Re: Application number SSD-10342

The Royal Agricultural Society of NSW (RAS) are located at Sydney Showground, Sydney Olympic Park and are a very close neighbour of Stadium Australia. We are pleased to provide the following comments concerning the material on exhibition.

Figure 6: Construction traffic routes and worst affected residences.

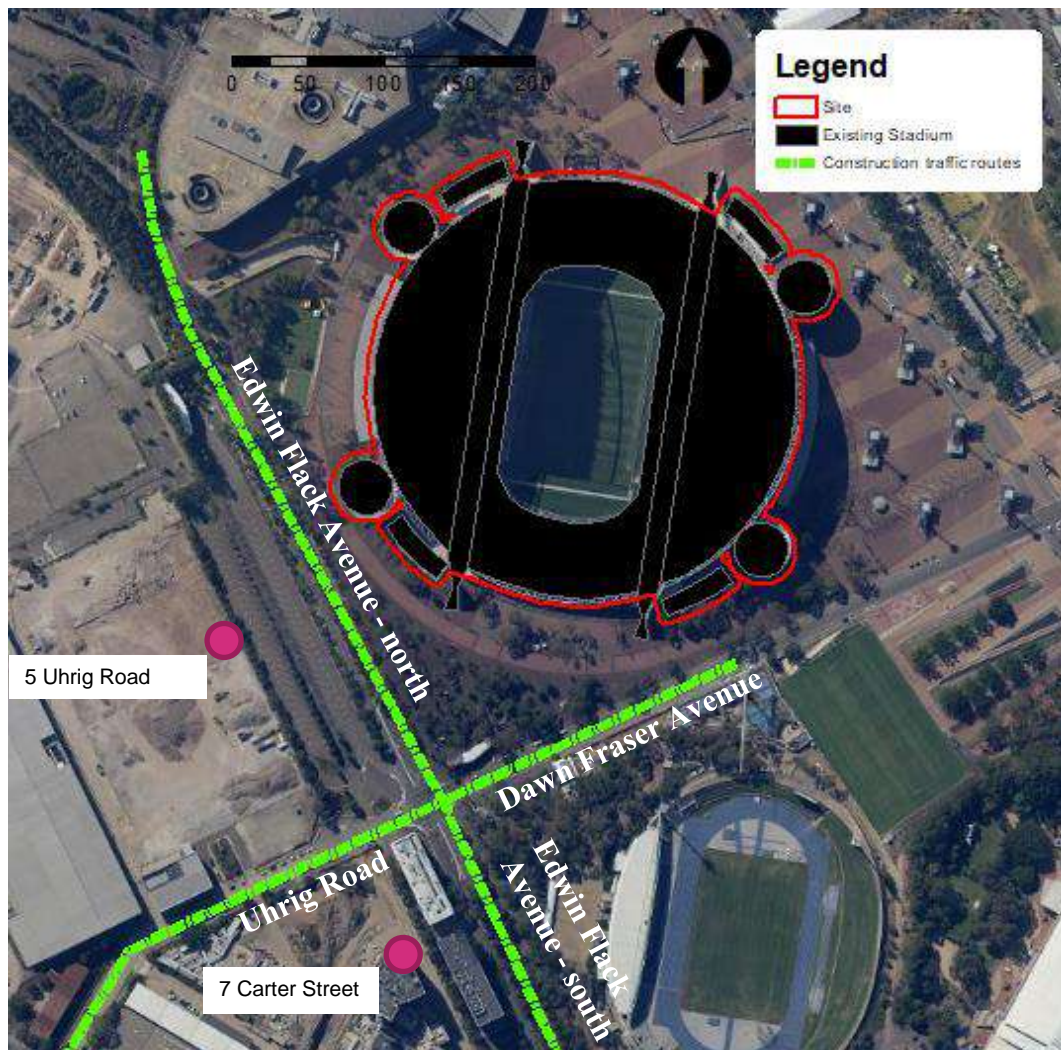
1. As detailed in Fig 52 of the EIS and in various other reports, we note the proposed inbound construction routes from the North along Australia Avenue. Please be advised that for approximately 35 days in and around Easter to facilitate the requirements of the annual Sydney Royal Easter Show (SRES), Australia Avenue from Murray Rose Avenue to Kevin Coombs Avenue is completely closed and will be unavailable to the aforementioned development.
